Consultee Comments for Planning Application 17194/23

Application Number: 17194/23

Address: 229 Wigan Road Westhoughton Bolton BL5 2AJ

Proposal: ERECTION OF A FIRST FLOOR EXTENSION TO FRONT AND SIDE AND CONVERSION OF GARAGE INTO A HABITABLE ROOM.

SITE:	229 Wigan Road Bolton, BL5 2AJ
TITLE:	Existing and Proposed Block Plan

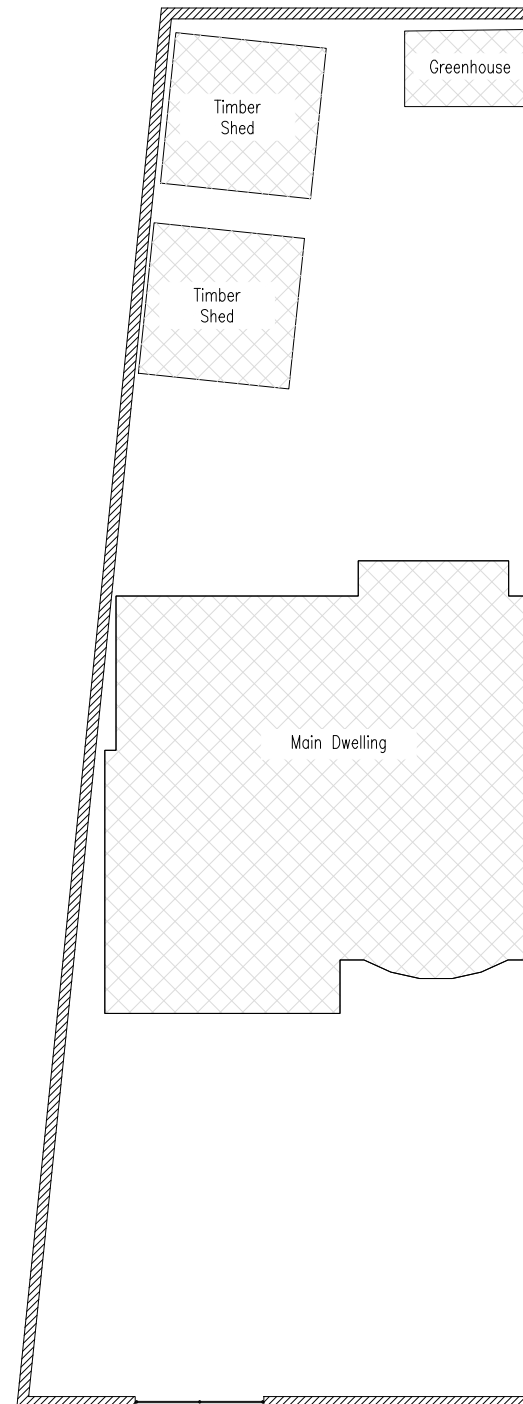
It needs to be ensured that the Councils residential parking standards can be met in full for the Local Highway Authority to be supportive of this application. Subject to satisfactory amended information being submitted indicating that this requirement can be met.

HS05-3 spaces (2.4m x 4.8m each space).
